# LUC Report Summary of Conclusions-

### Opportunities for scheme improvement and mitigation

#### Area 7 Proposed Native Woodland Planting

Map Title
Figure 6.2
Ancient Woodland, Ancient Tree Inventory and Habitats of Priority Importance
Scheme: 0102, M6 Junction 40 to Kemplay Bank
Sheet 1 of 10

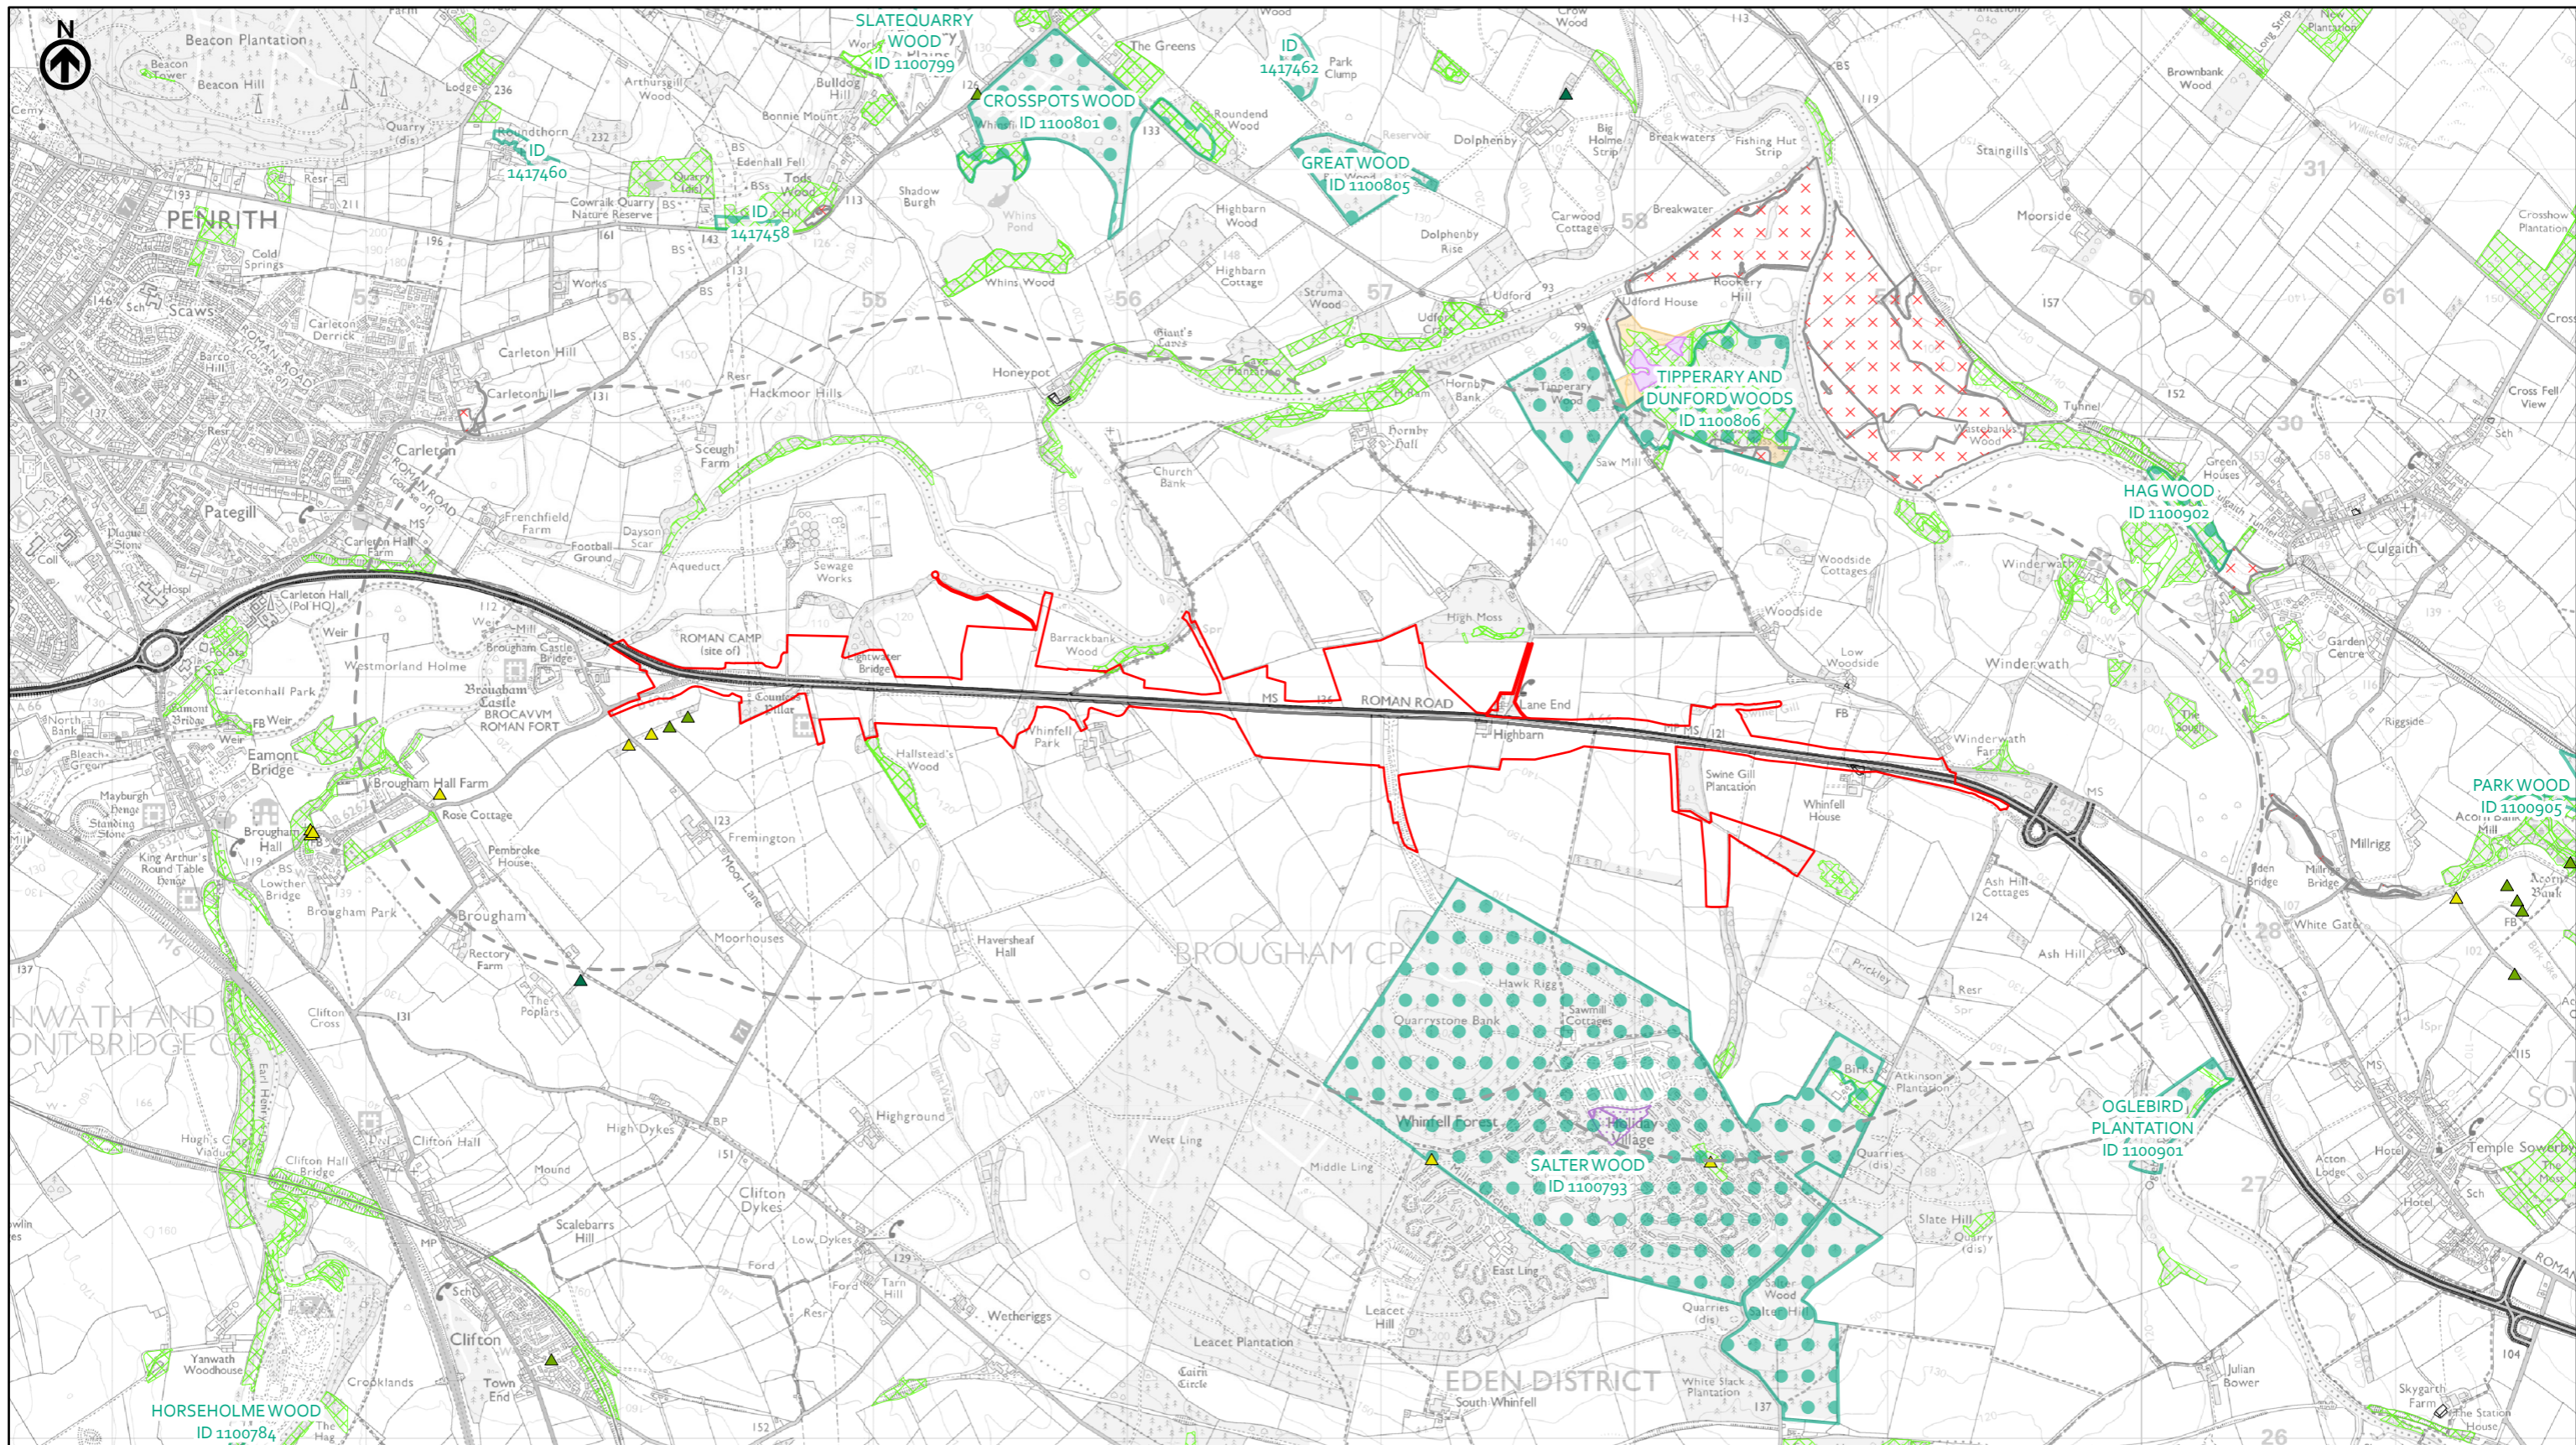
1.1 It is strongly advised that Area 8 should be used for mitigation woodland instead of Area 7. This land is already separated from the parkland and planting here would not alter the parkland character to the same degree. Area 8 can be accessed via the underpass beneath the M6. This would avoid the need for a strip of land alongside the woodland belt, where tracking with vehicles would damage the roots of trees and threaten the health and integrity of the nature boundary trees that presently screen the M6. The long access track that is proposed abutting the trees, and which at one point drops steeply off a river terrace (too steeply to be routed that way) could then be completely avoided, with access being taken off Skirsgill Lane instead. Additional land between the M6 and Skirsgill Lane, east of the motorway, could also be planted, providing further mitigation.

It is not appropriate to plant mitigation woodland within the intact parkland, where there are parkland tree specimens associated with this estate. This would be out of character and would adversely alter long views from the house, and from the parkland back towards the house – and thus the setting of the listed building. It would not respect the historic character of the parkland as it runs down to the river in this location. As well as being valued for its historic character, the semi-improved grassland and specimen trees of The Park are of landscape and
